# ***City of Albuquerque***

***RE: COMCAST CABLEVISION, Chico & Rhode Island NE (K19-D124A). GRADING  
AND DRAINAGE PLAN FOR BUILDING PERMIT APPROVAL. ENGINEER'S  
STAMP DATED MAY 2, 2001.***

COMCAST CABLEVISION
8000 CHICO ROAD
ALBUQUERQUE, NEW MEXICO
GRADING AND DRAINAGE PLAN

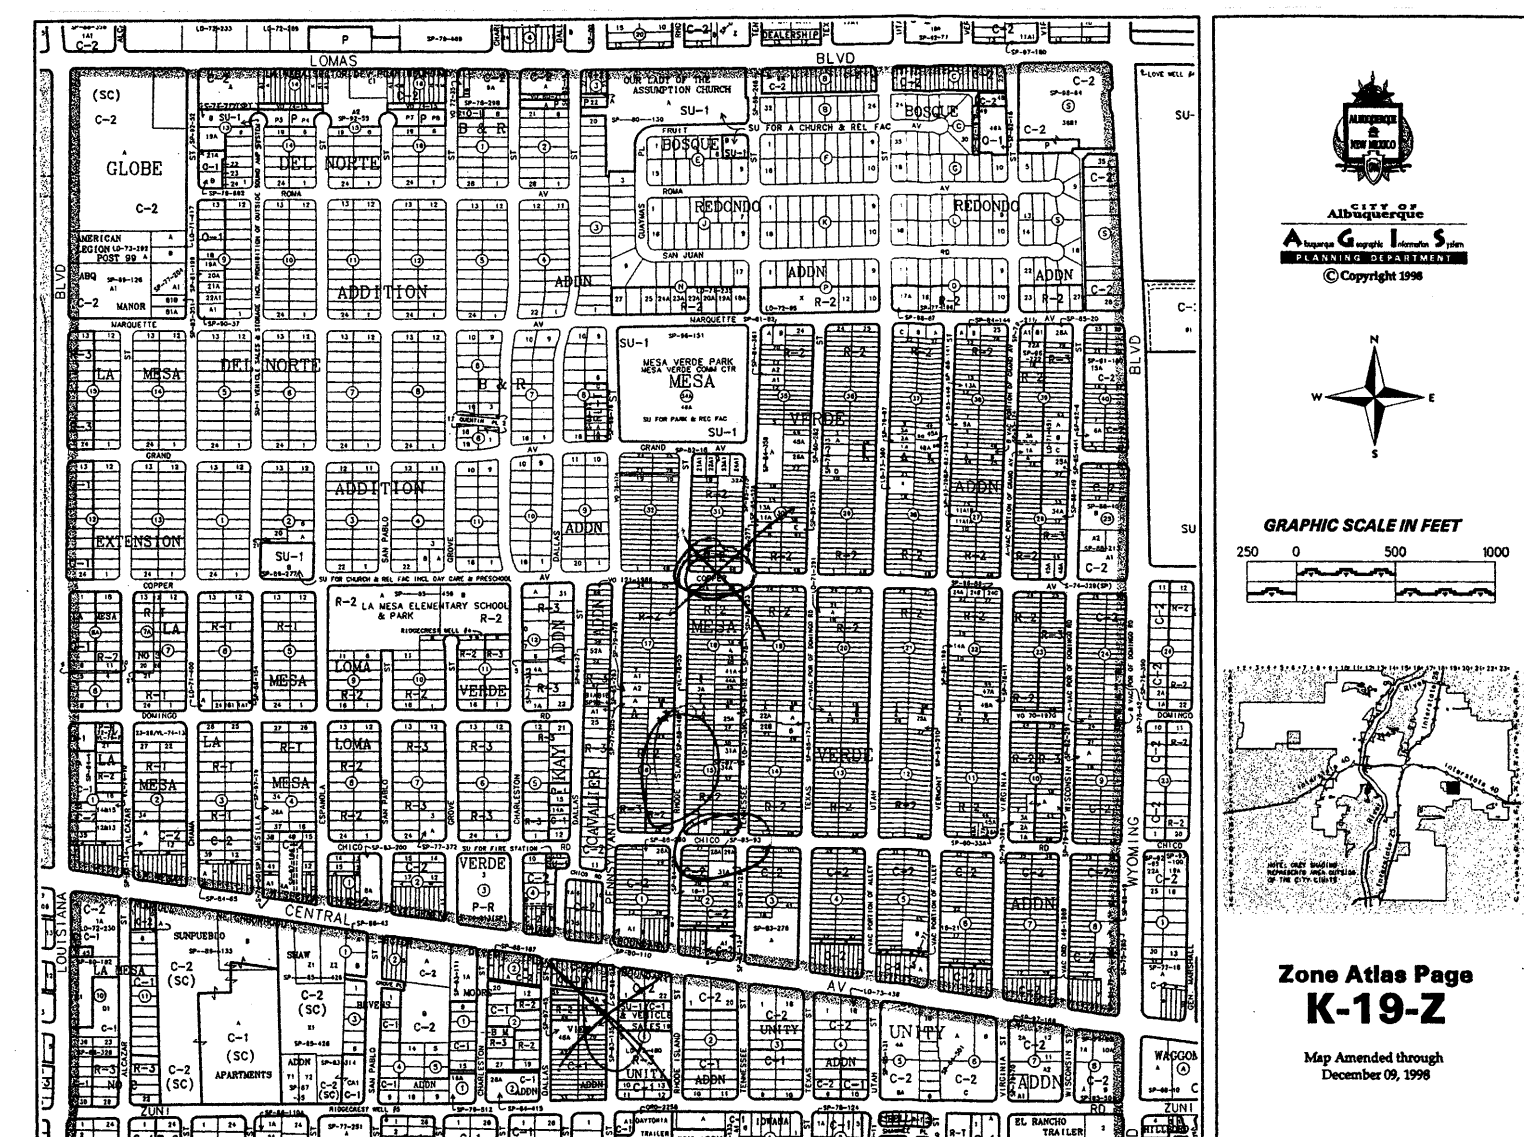
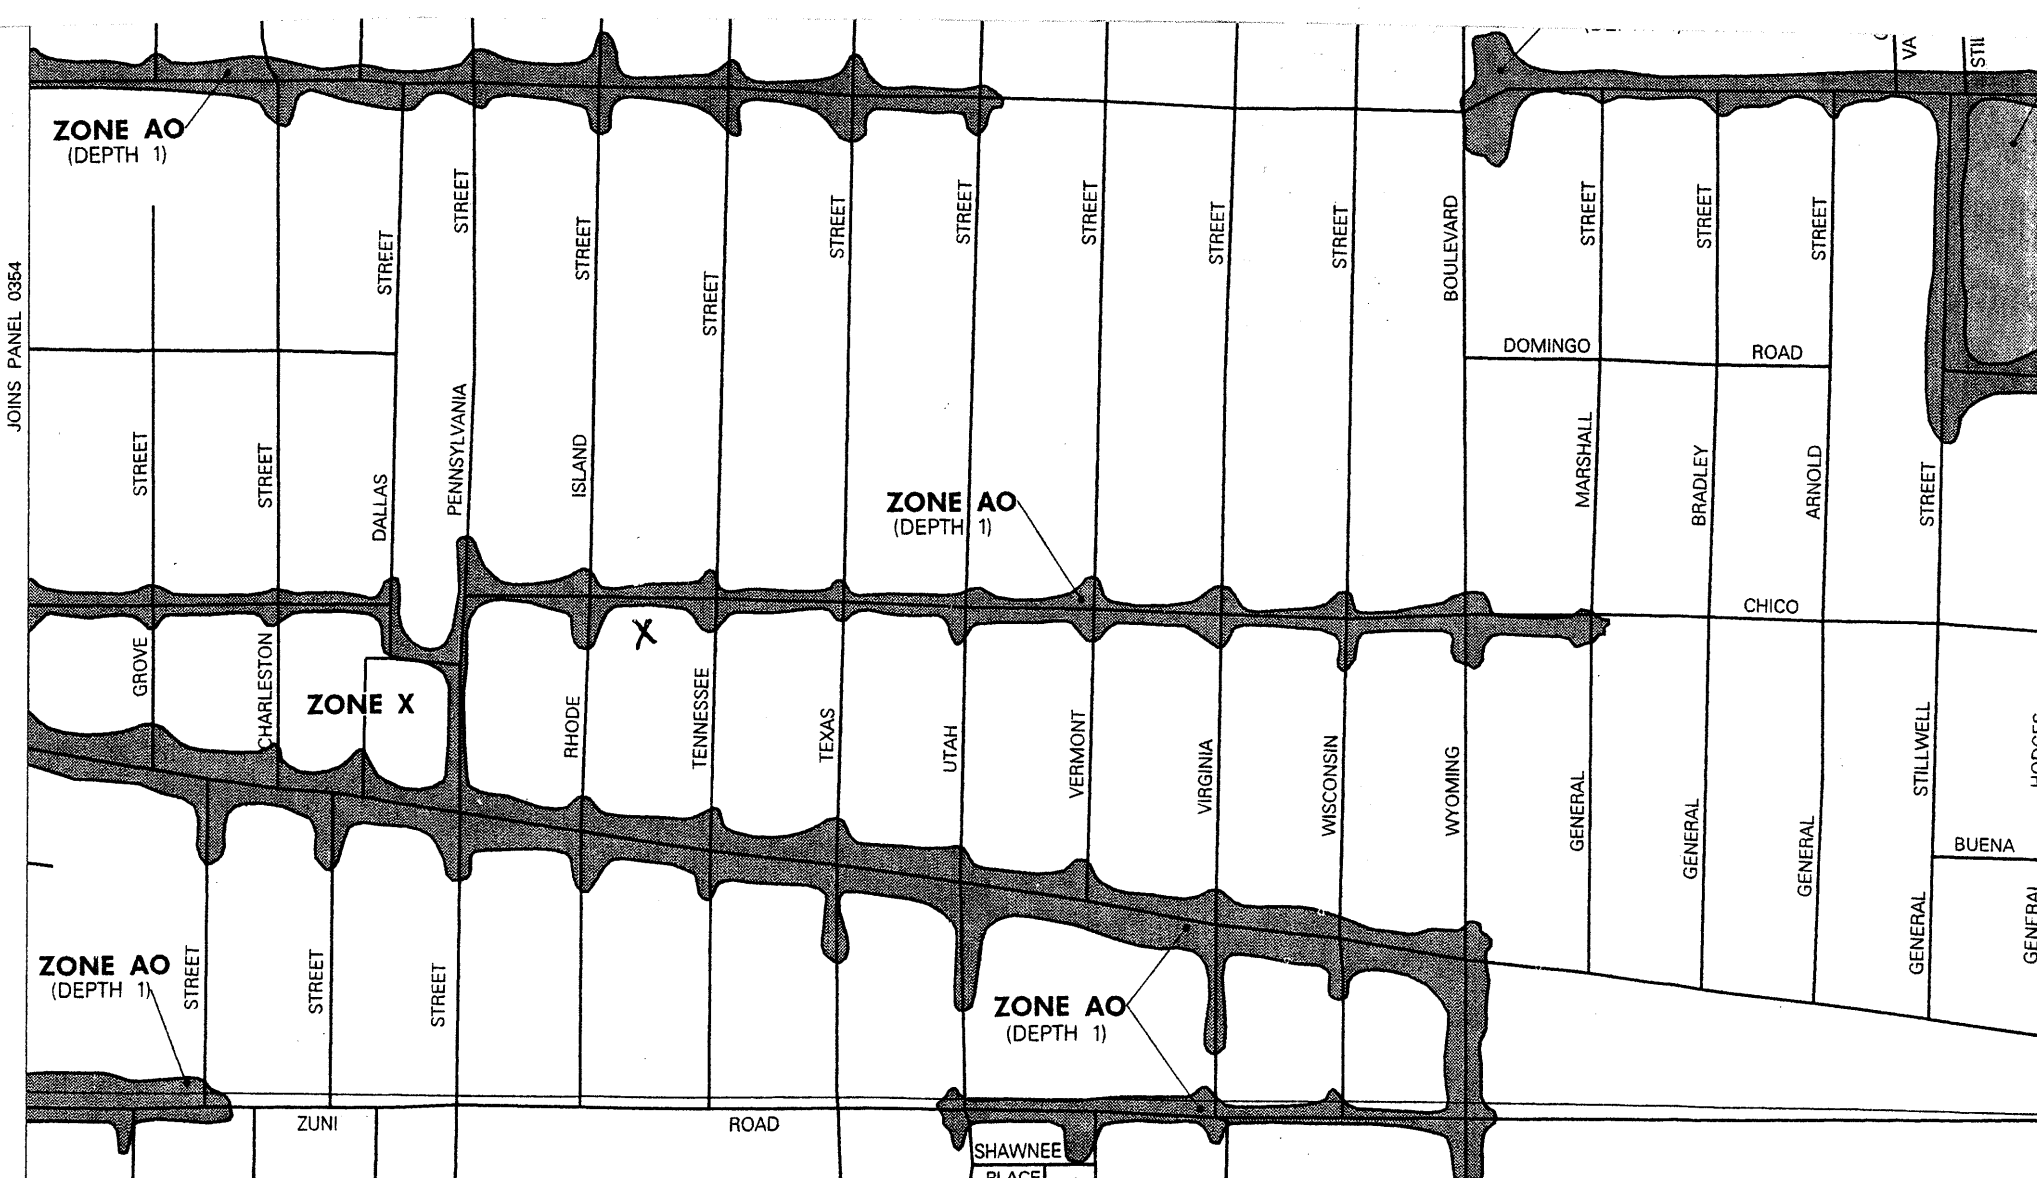
Please attach a copy of this approved plan to the construction sets prior to sign-off by Hydrology.  
\*\*\*Indicate site location on FEMA Map. Blow up and indicate project location on VICINITY Map K-19.
